Planning and Development Services
Arun District Council
Arun Civic Centre
Maltravers Road
Littlehampton
West Sussex
BN17 5LF

Developer Services
Southern Water
Sparrowgrove House
Sparrowgrove
Otterbourne
Hampshire
SO21 2SW

PLAN-017056

Proposal: Application for approval of matters reserved by conditions imposed under BR/54/16/PL relating to Conditions(s) 10 - Surface water drainage scheme, 16 - Measures to divert public sewers, 17 - Foul & surface water sewerage disposal details & 27 - Details of exact location of the rising main & foul sewer pipe identified & plan identifying Southern Water Infrastructure of locations of the pipe run.
University of Chichester, Upper Bognor Road, Bognor Regis, PO21 1HR.
BR/342/16/DOC

CLIENT:	UNIVERSITY OF CHICHESTER	PROJECT:	UNIVERSITY OF CHICHESTER EDT PARK BOGNOR REGIS
ARCHITECT:	STRIDE TREGLOWN LTD.	TITLE:	PROPOSED DRAINAGE LAYOUT EDT BUILDING

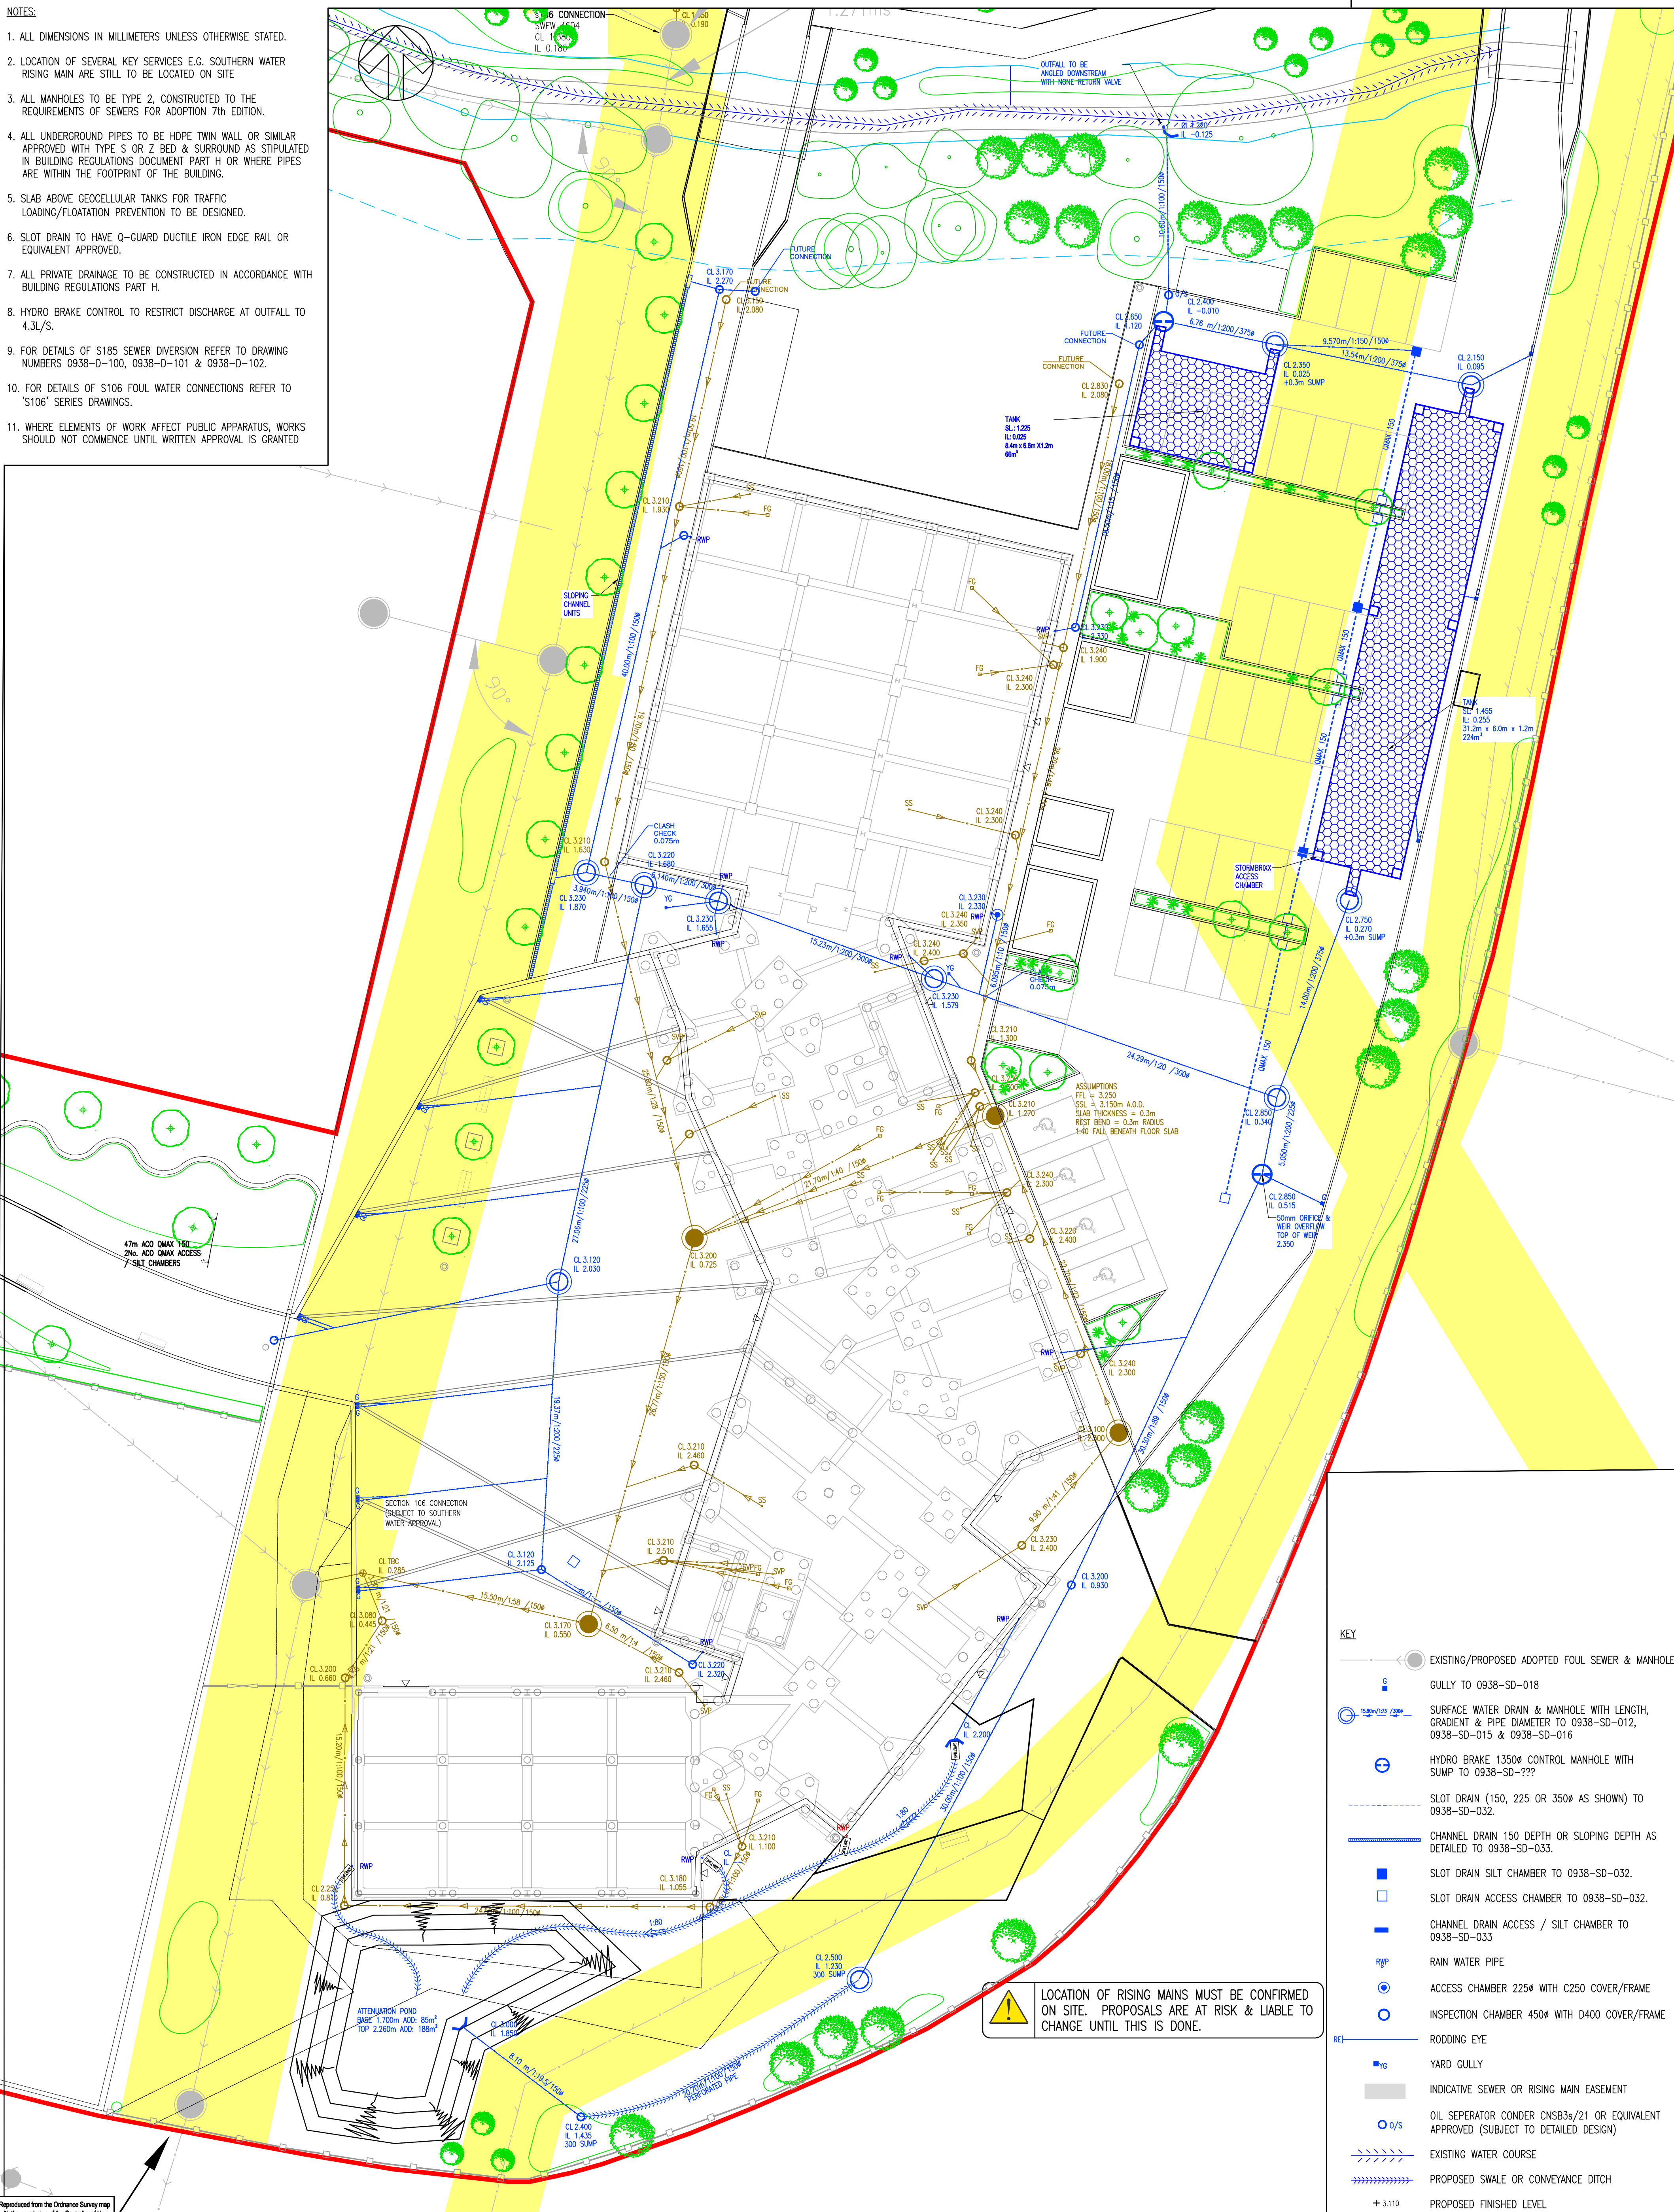
The Council's Building Control officers or technical staff and Environment Agency should be asked to comment on the surface water disposal from the proposed development. No new soakaways, swales, ponds, watercourses or any other surface water retaining or conveying

features (including cellular storage) should be located within 5 metres of a public gravity sewer (also adoptable), rising main or water main.

TITLE: PROPOSED FOUL DRAINAGE NETWORK
HALLS OF RESIDENCE

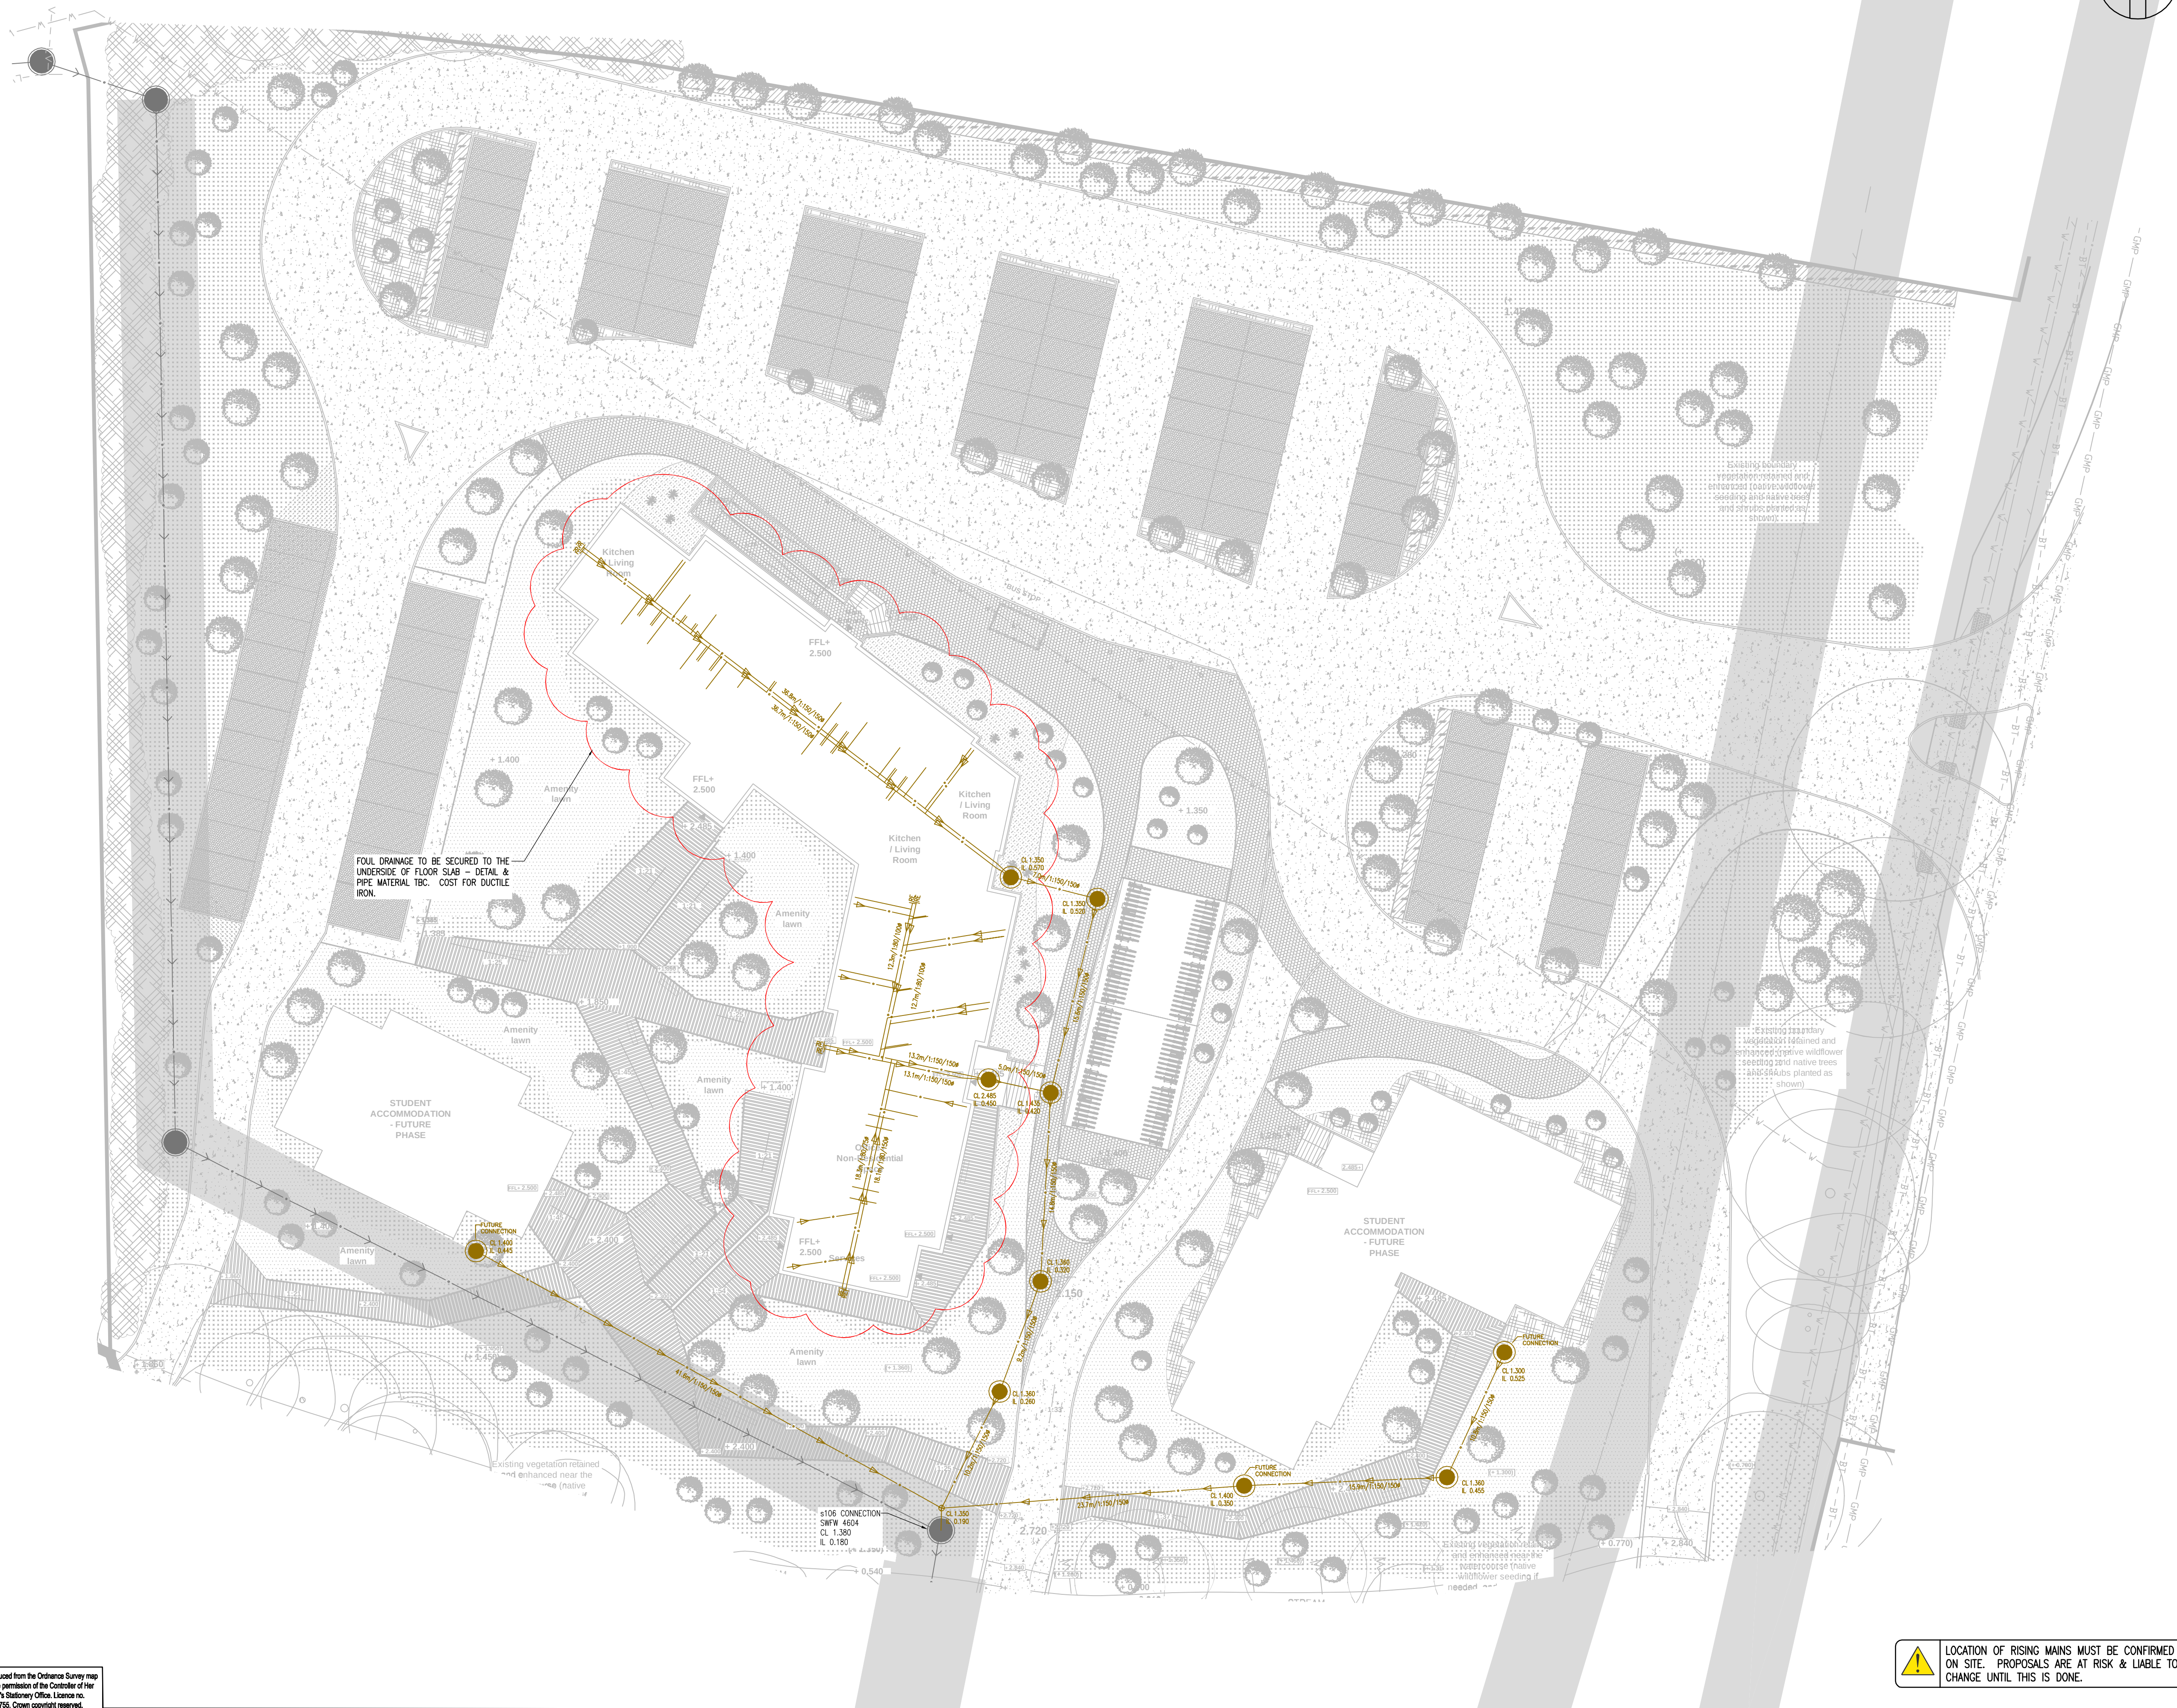
Southern Water would recommend discharge of condition 17 relating to foul drainage. An approval for connections to the public foul network should be obtained under Section 106 of the Water Industry Act. The connections can be carried out only on completion of the public foul sewer diversion works (see above).
